from
**Southern
Water**

Your ref
A/158/20/DOC

Proposal: Approval of details reserved by condition imposed under ref A/99/17/OUT relating to Condition Nos 23 - SuDs, 24 - foul water sewerage disposal, 25 - discharge flows to watercourses, 26 - access & maintenance of watercourses & culverts and 28 - Flood Risk Assessment.

Site: A/158/20/DOC: - Land South of Water Lane, Angmering, BN16 4EP.

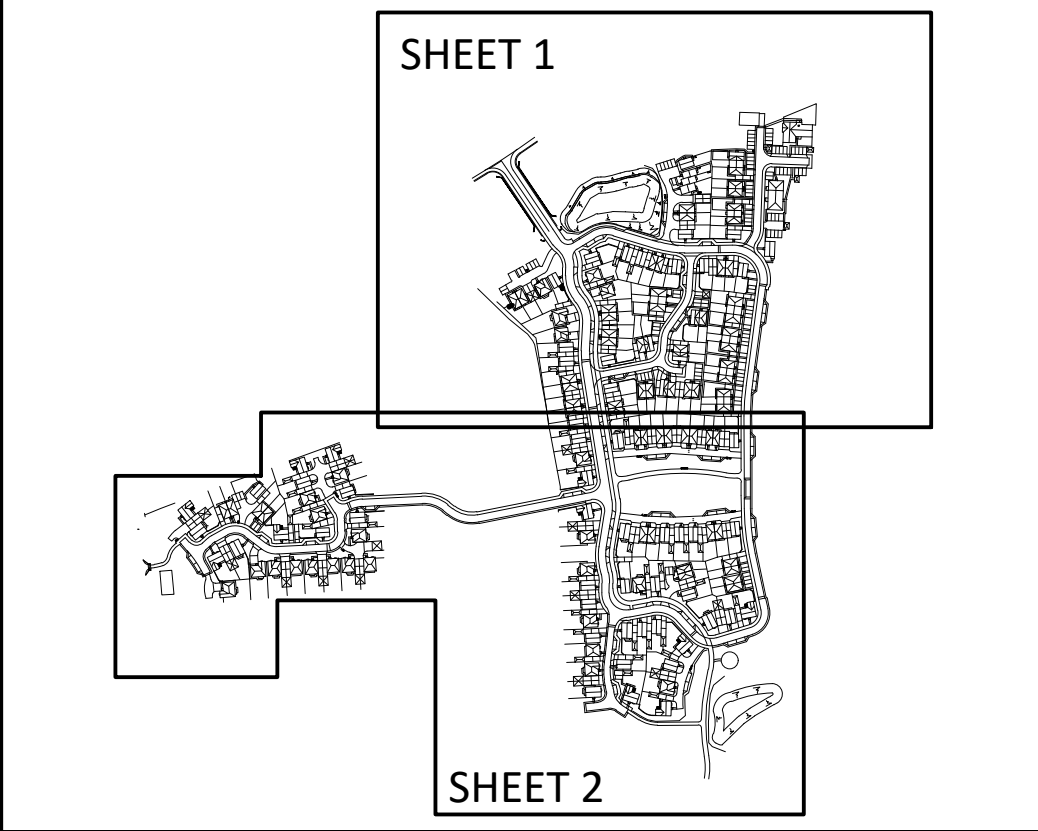
Southern Water cannot recommend discharge of condition regarding drainage. The submitted drainage layout shows proposed development lies within the standoff distance from public water distribution main which would not be acceptable to Southern Water.

The exact position of the public water mains must be determined on site by the applicant. The drainage proposals shall include protection measures to be shown to satisfy the requirement to maintain standoff distances for public water mains.
